MEMORANDUM

TO: Nell Donaldson, Planner
FROM: David Senus, P.E.
DATE: March 12, 2015
RE: Brighton Ave Hotel Redevelopment, Level III Site Plan Application

Woodard & Curran has reviewed the Final Level III Site Plan Application and Response to Comments letter for the proposed hotel redevelopment project located at 1210 Brighton Avenue in Portland, Maine. The project involves the demolition of an existing 135 room motel and the construction of a new 86 room hotel, parking lot, and utilities.

Job No.: 257  
Date: Nov. 14, 2014  
Scale: NTS  
Drawn: SWC  
Checked: WRW  
Sheet No.:  
**C4.5**

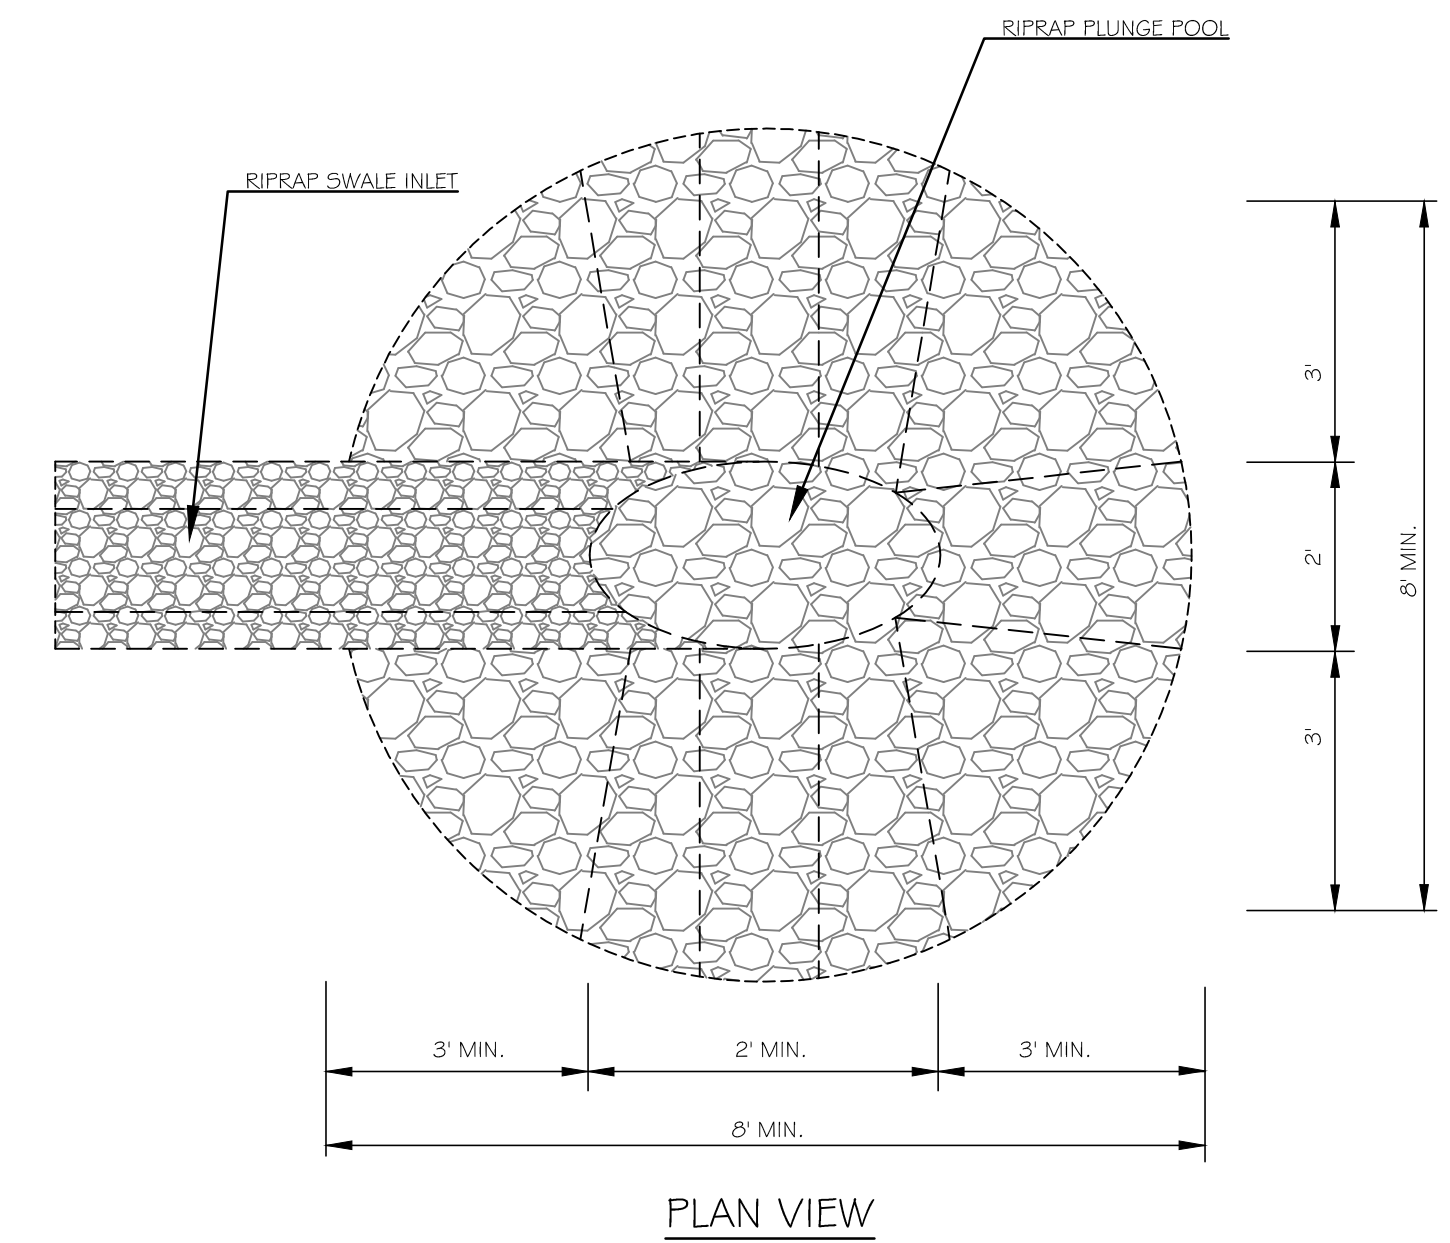
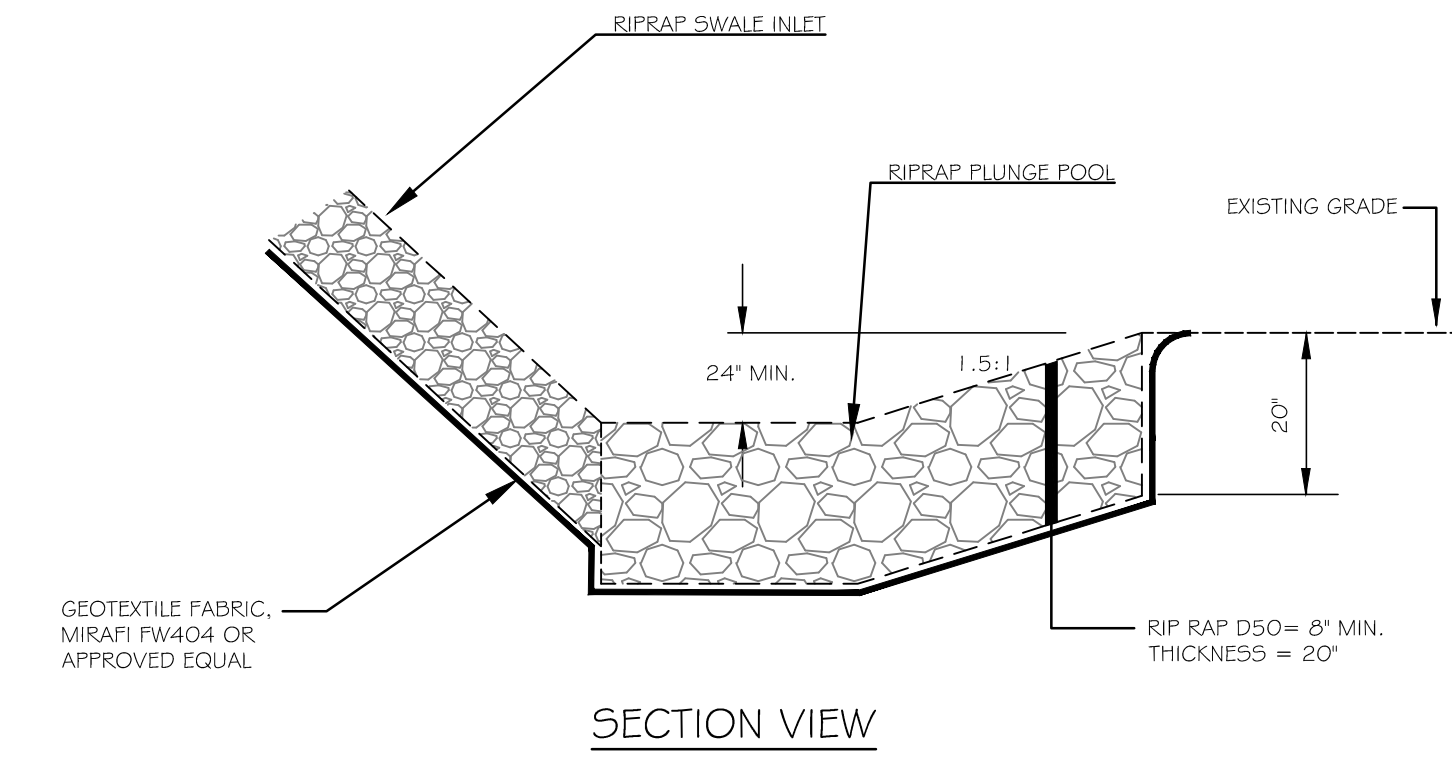
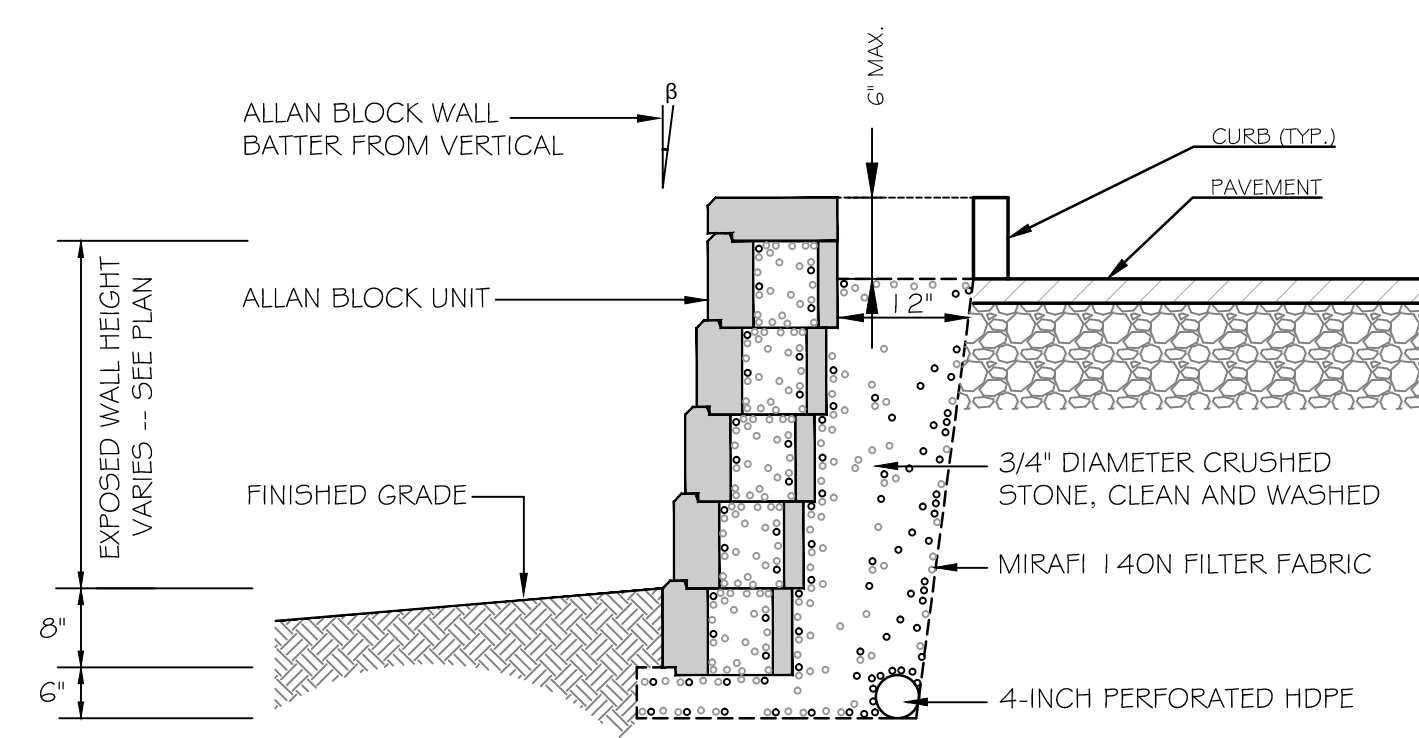
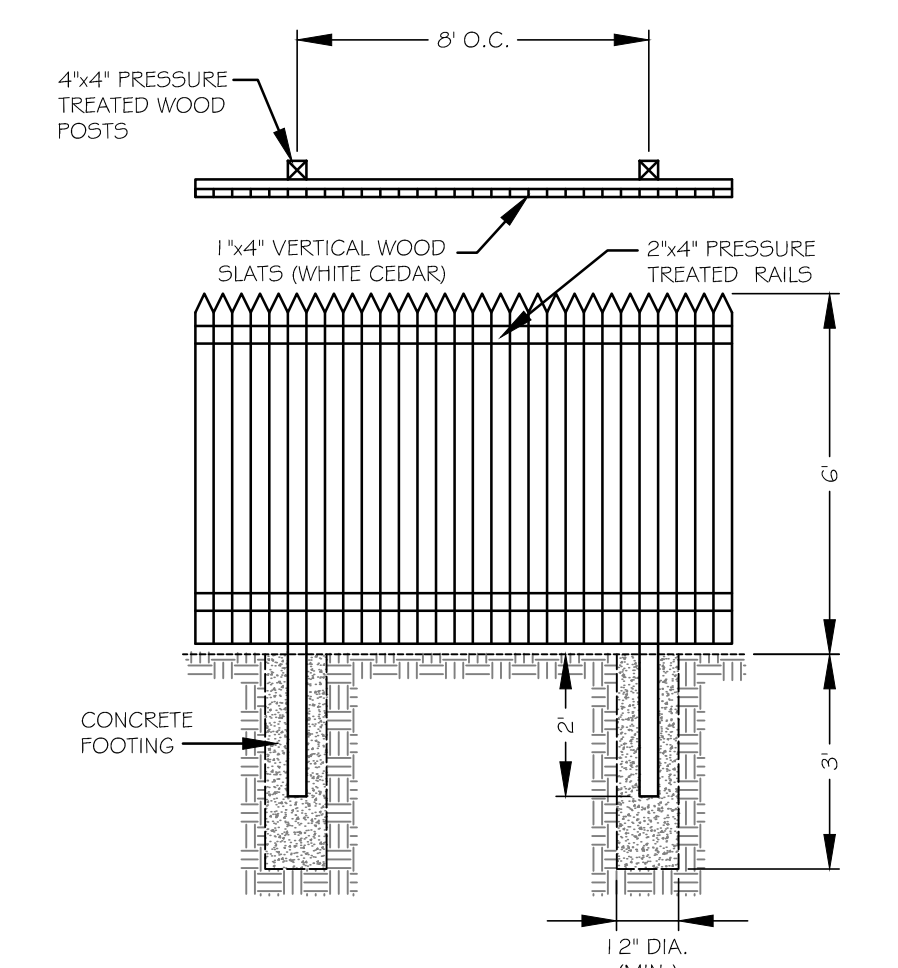
1. A stormwater outfall proposed on the southern portion of the site (AP#2 on sheet D2.0) discharges to an existing swale within a CMP easement. The Applicant proposes a riprap apron at the pipe outlet. We recommend that the Site Plan approval include a condition requiring that the Applicant's engineer inspect the stormwater outfall AP#2 on Sheet D2.0 and provide a written description and photographs of this outlet, along with any additional proposed stabilization measures as determined necessary for review and approval by the City. Walsh Engineering Associated has stated that they will assess and document the condition of the outfall location once the snow has melted and will provide design details to the city for any additional required stabilization measures.

2. The plan has been revised to indicate that a construction and drainage easement shall be obtained from the City of Portland for the areas associated with the riprap swales along the eastern boundary of the site. Easements should be drafted for these riprap swales; this can be stated as a condition of approval for the project.
